**Consultation Response from KC,  
Trees****2024/93594 Hollinghurst Farm, 76, Hall Ing Lane, Honley, Holmfirth, HD9 6QR****Erection of 9 dwellings including associated works****Date Responded: 22/12/2025****Responding Officer: JD****Responding Ref: 03/10**

DRAWING DESCRIPTION			
PLOT 8			
JOB TITLE			
HOLLINHURST FARM			
HONLEY			
CLIENT			
Kingsman Homes			
DRAWN BY		SCALE	1:100 @ A1
DATE		DRAWING NO.	REVISION
December 2024		1020/00-07	.
CHECKED

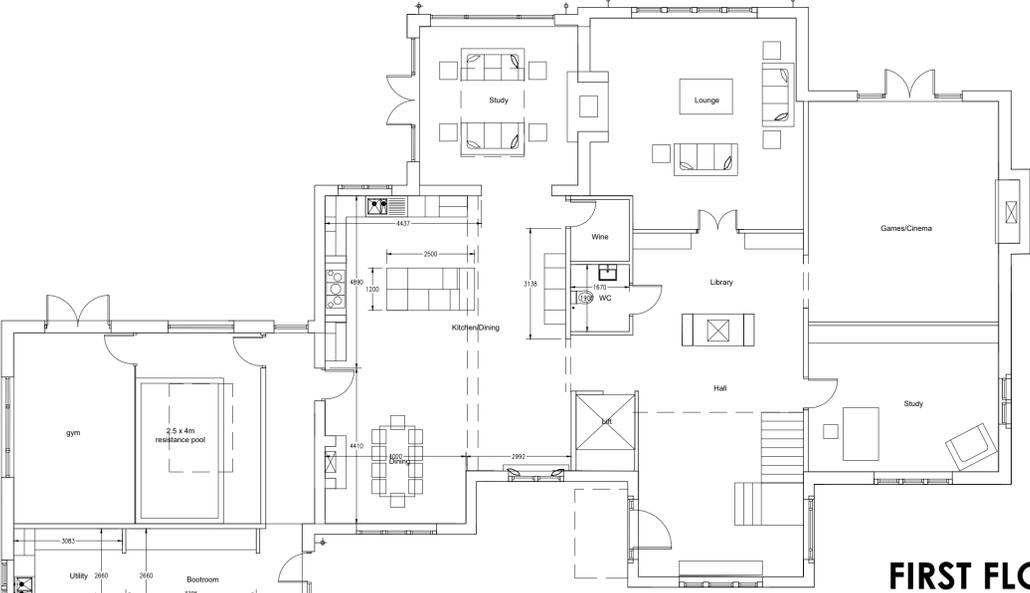
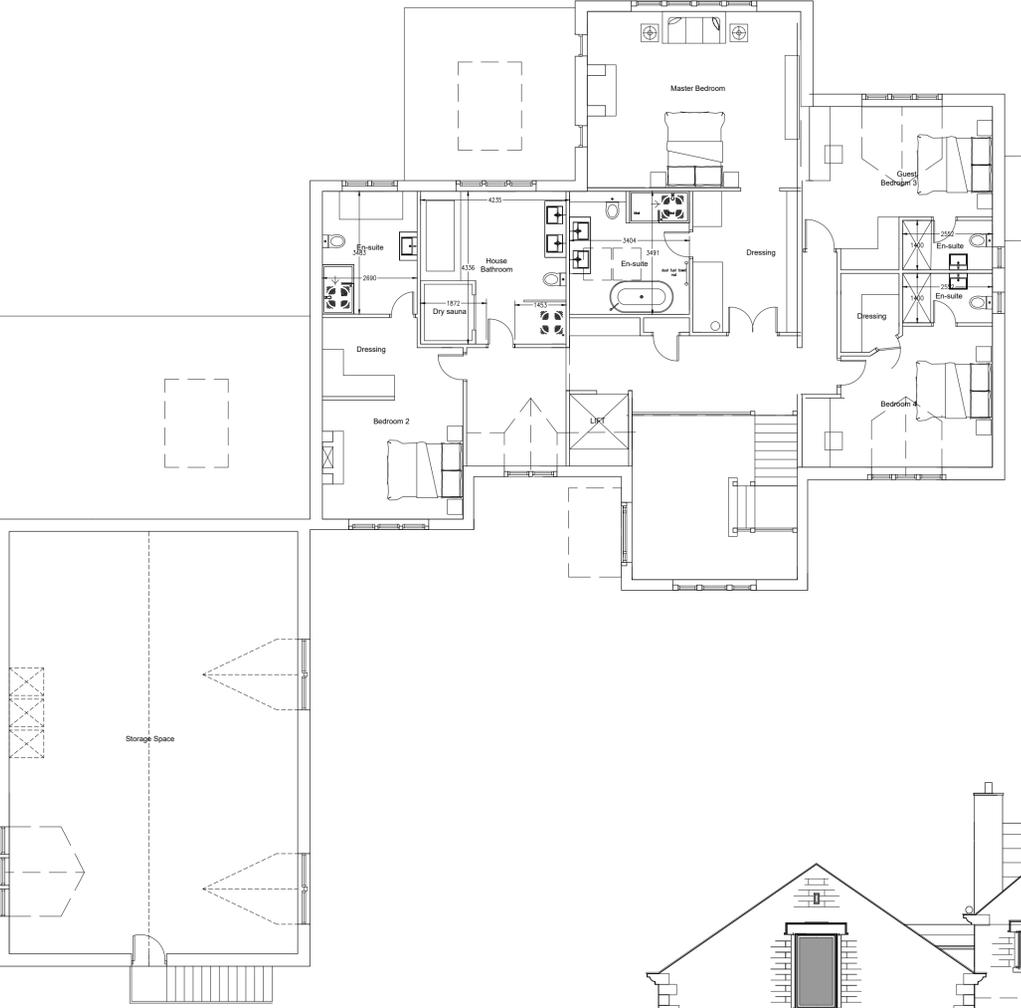
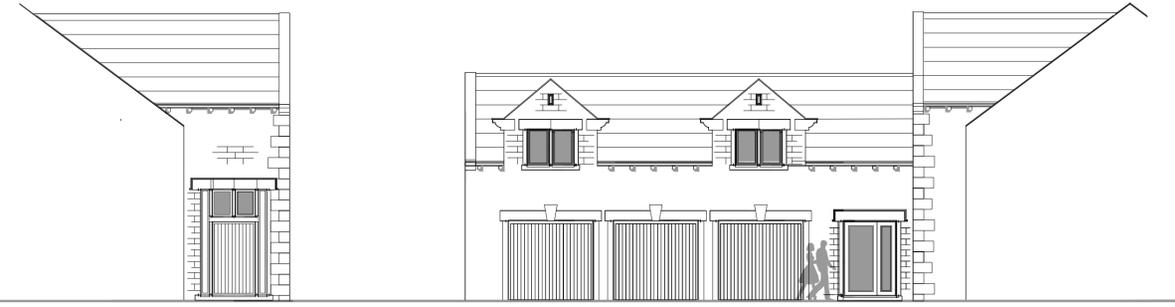
From the submitted proposed block layout plan it appears that plot 8 (more specifically the garage of plot 8) may be within the Root Protection Area (RPA) of the protected trees. With a slight design change or specialist engineering this may be achievable whilst being outside of the adjacent RPA's.

There is a holding objection until an Arboricultural Impact Assessment (AIA) is submitted which shows the extent of the neighbouring trees RPA's and or how the development will be constructed as to not have an impact on said trees.
